**CITY OF PORTLAND, MAINE
DEVELOPMENT REVIEW APPLICATION
PLANNING DEPARTMENT PROCESSING FORM
DRC Copy**

Auburn Estates, Lot #7

Approval Conditions of DRC

SINGLE FAMILY RESIDENTIAL LOT PLAN

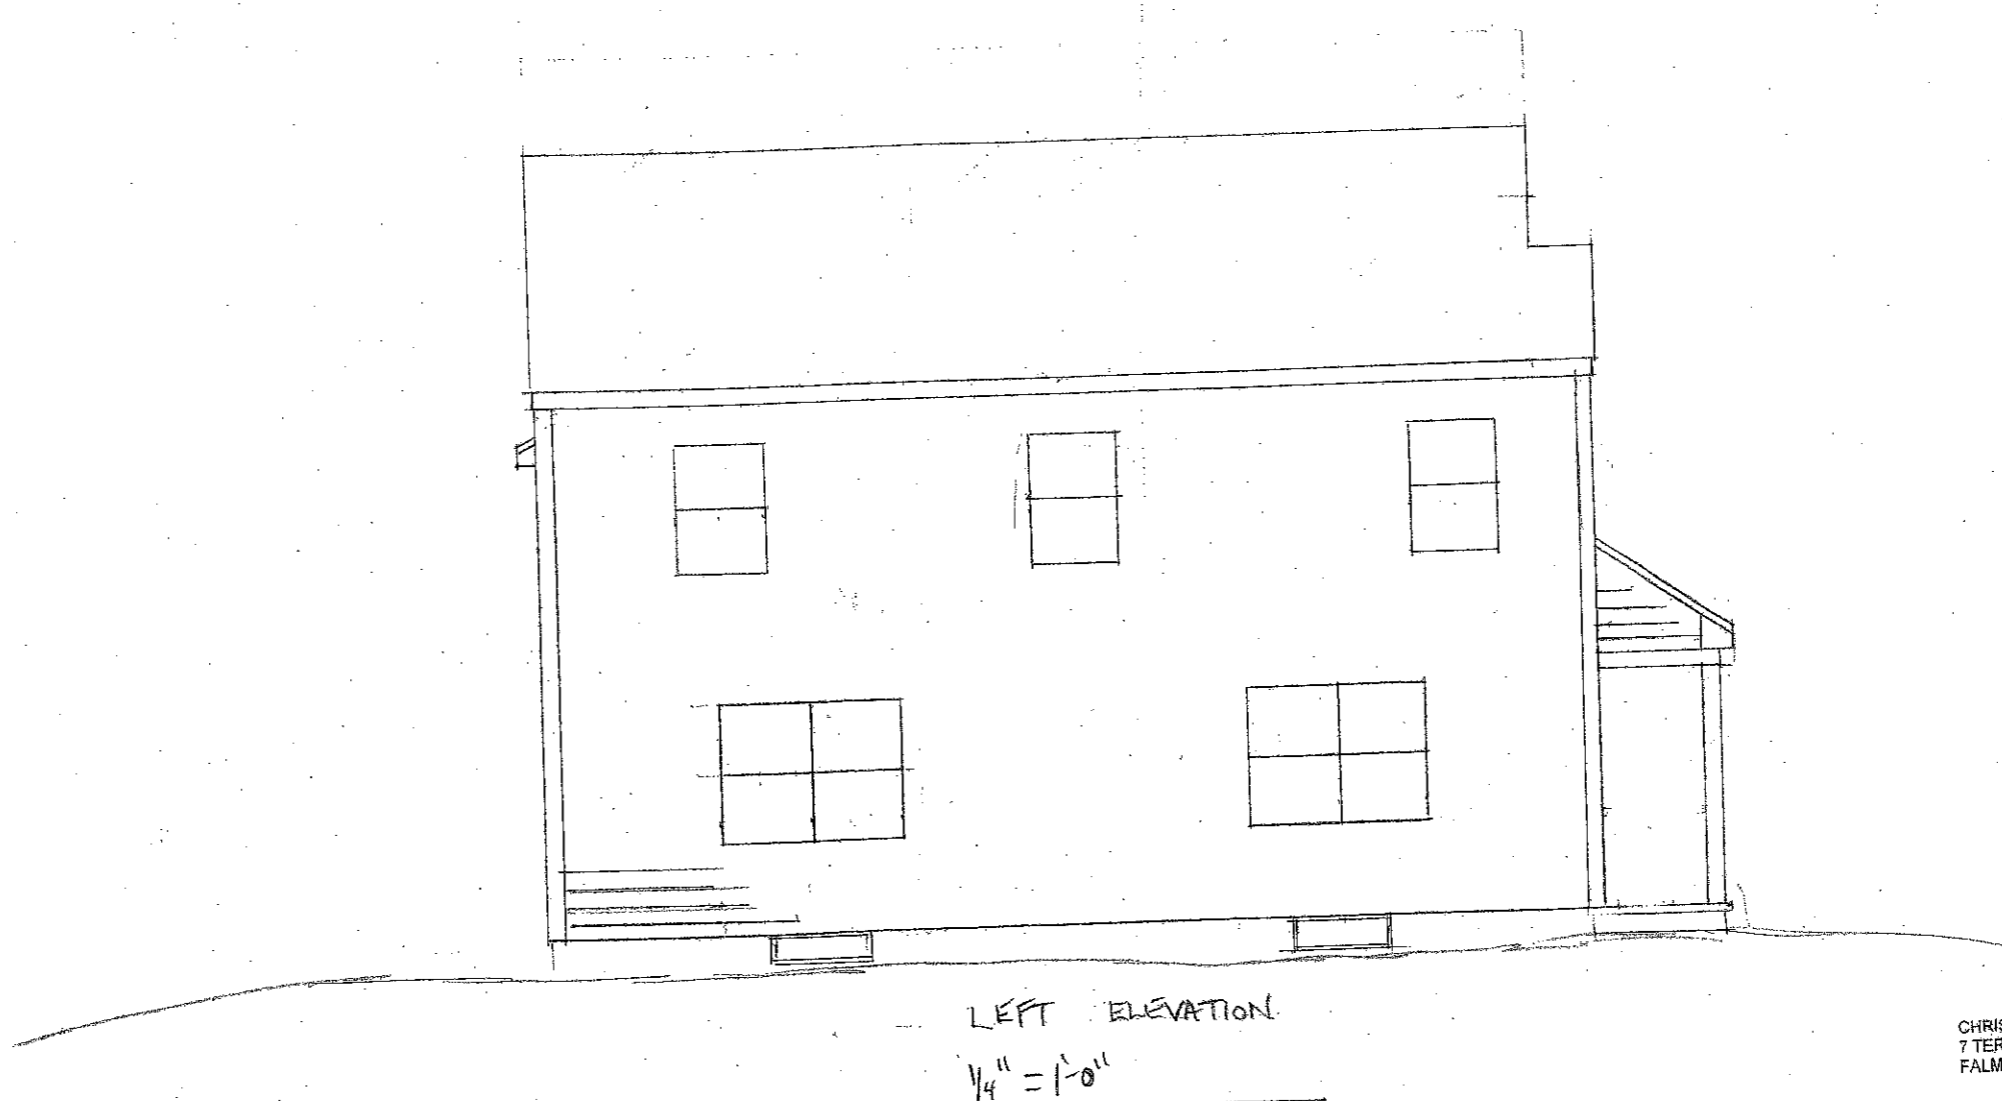
- 1 THE ROADWAY STORM DRAIN SYSTEM MUST BE REDESIGNED IN ORDER TO TIE IN THE FOUNDATION DRAIN FROM THE BUILDING.
